Consultation Response from KC Highways
2019/91638 land at, Abbey Road North, Shepley, Huddersfield, HD8 8DY
Reserved matters application for erection of 27 dwellings pursuant to outline permission 2017/92233 for erection of up to 34 dwellings
Date Responded: 01/11/19 Responding Officer: J Turner Responding Ref: K12-40/15

This is a reserved matters application seeking approval for the erection of 22 dwellings pursuant to permission 2017/92233 at land at Abbey Road, Shepley.

1305/11/15

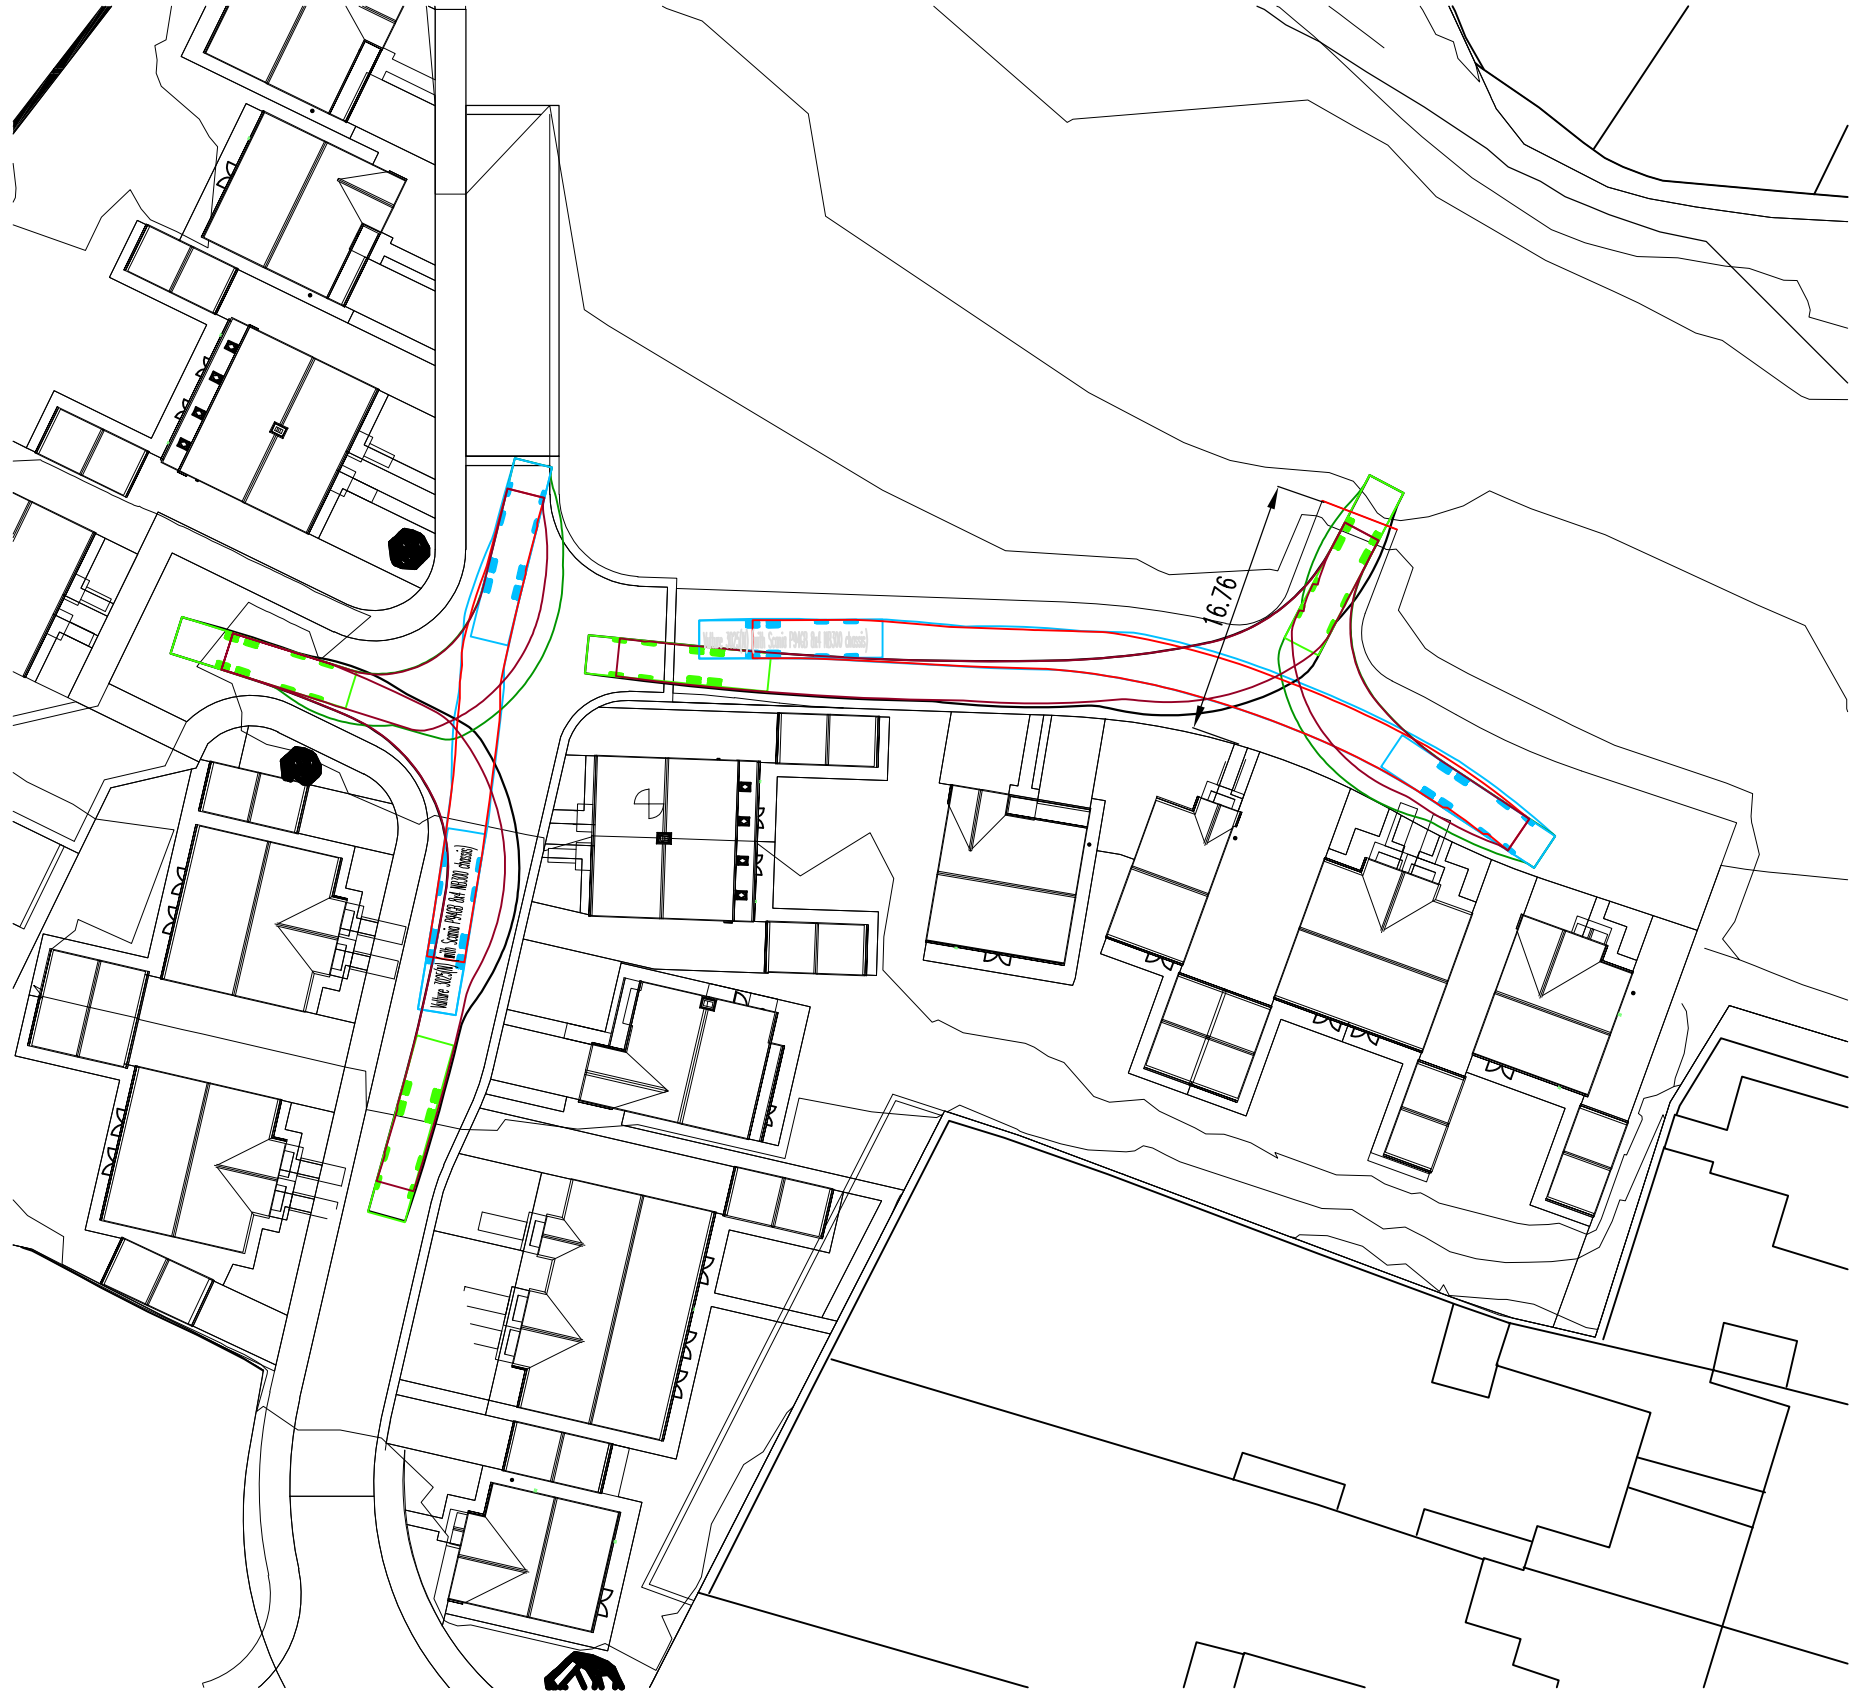
- Verification of the dimensions of the refuse vehicle used. This needs to be 11.85m in length, but the text on the type of wagon used is illegible on the drawing. The Vulture 3025(N) used in drawing no. 1305/11/15 is acceptable, but confirmation is required.

TITLE	SECTION 38 LAYOUT				
PROJECT	ABBEY ROAD NORTH, SHEPLEY				
CLIENT	CAMSTEAD				
DRAWING STATUS	PRELIMINARY				
Scale	1:500 @ A1	Date	APR 19	Drawn	DJC
		Chk.	TC		
Drg. No.	1305/11/02	Rev	A

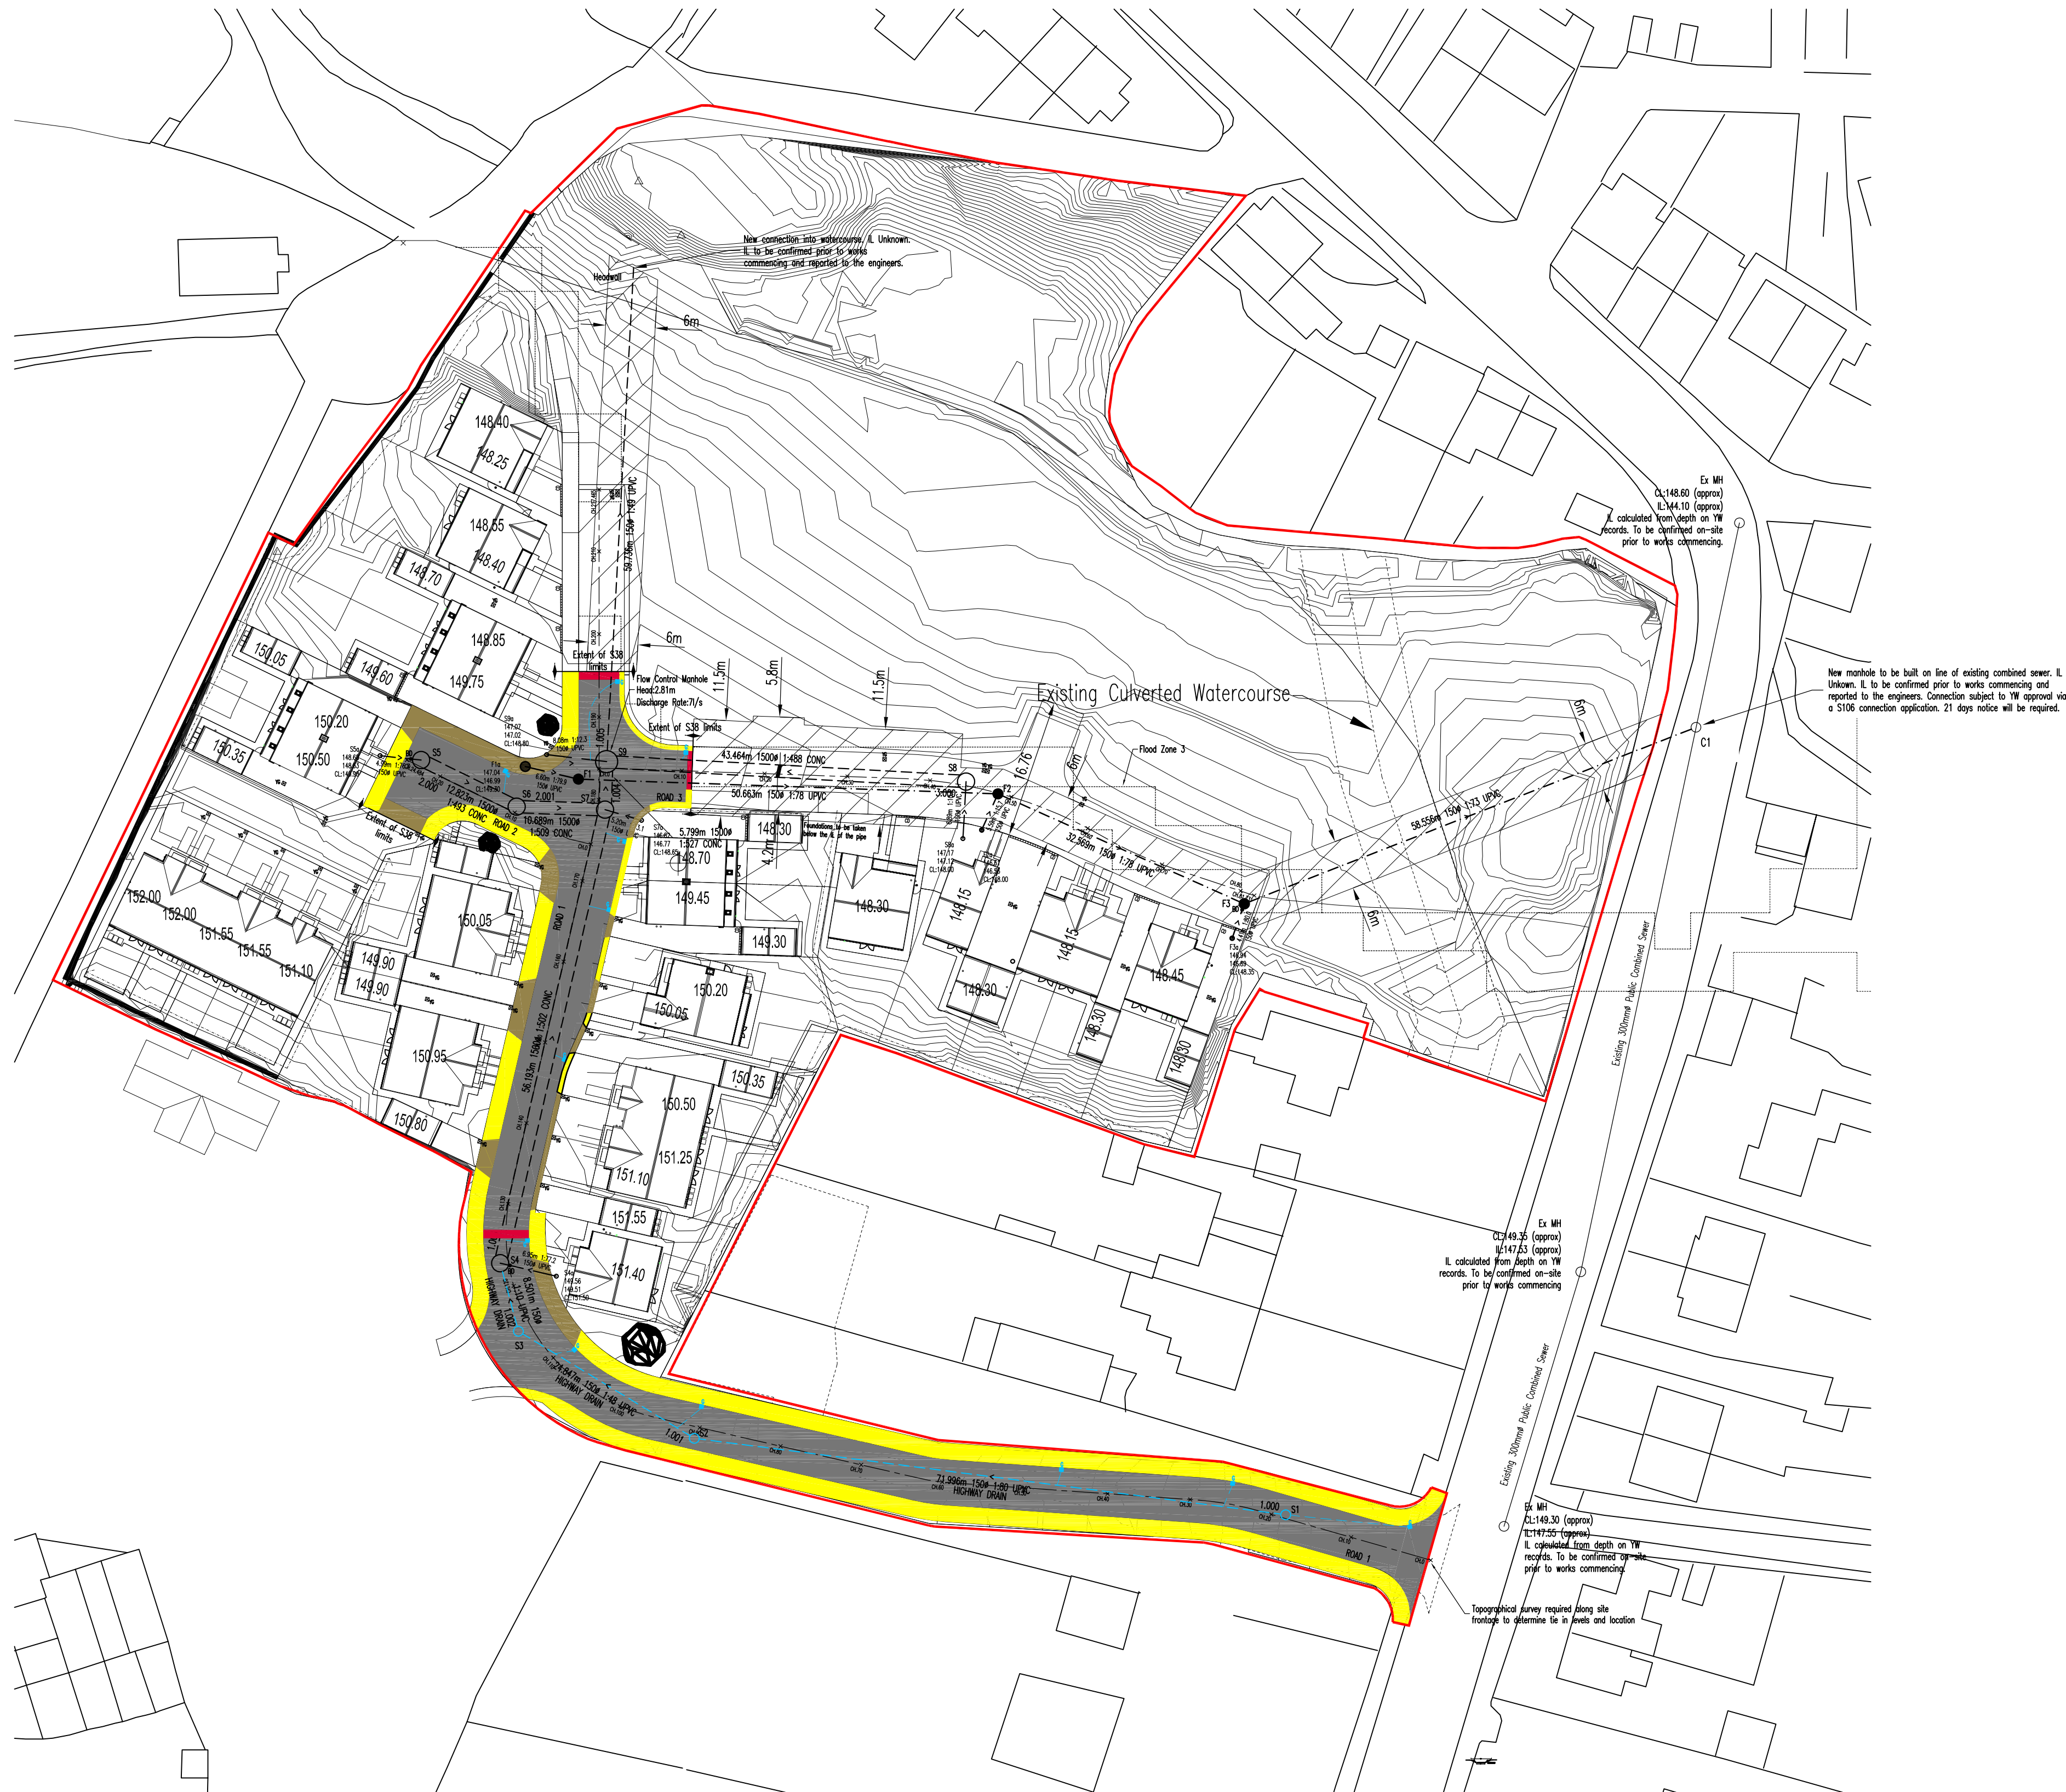
- Further construction details of the carriageway to be considered by the council's Section 38 department. As the refuse vehicle is intended to use private drives, these will also have to be made up to adoptable standard, or at least be accepted to be sufficiently robust to withstand refuse and delivery vehicles. Detail of kerbing for the private drive serving plots 17-21 will need to be submitted.
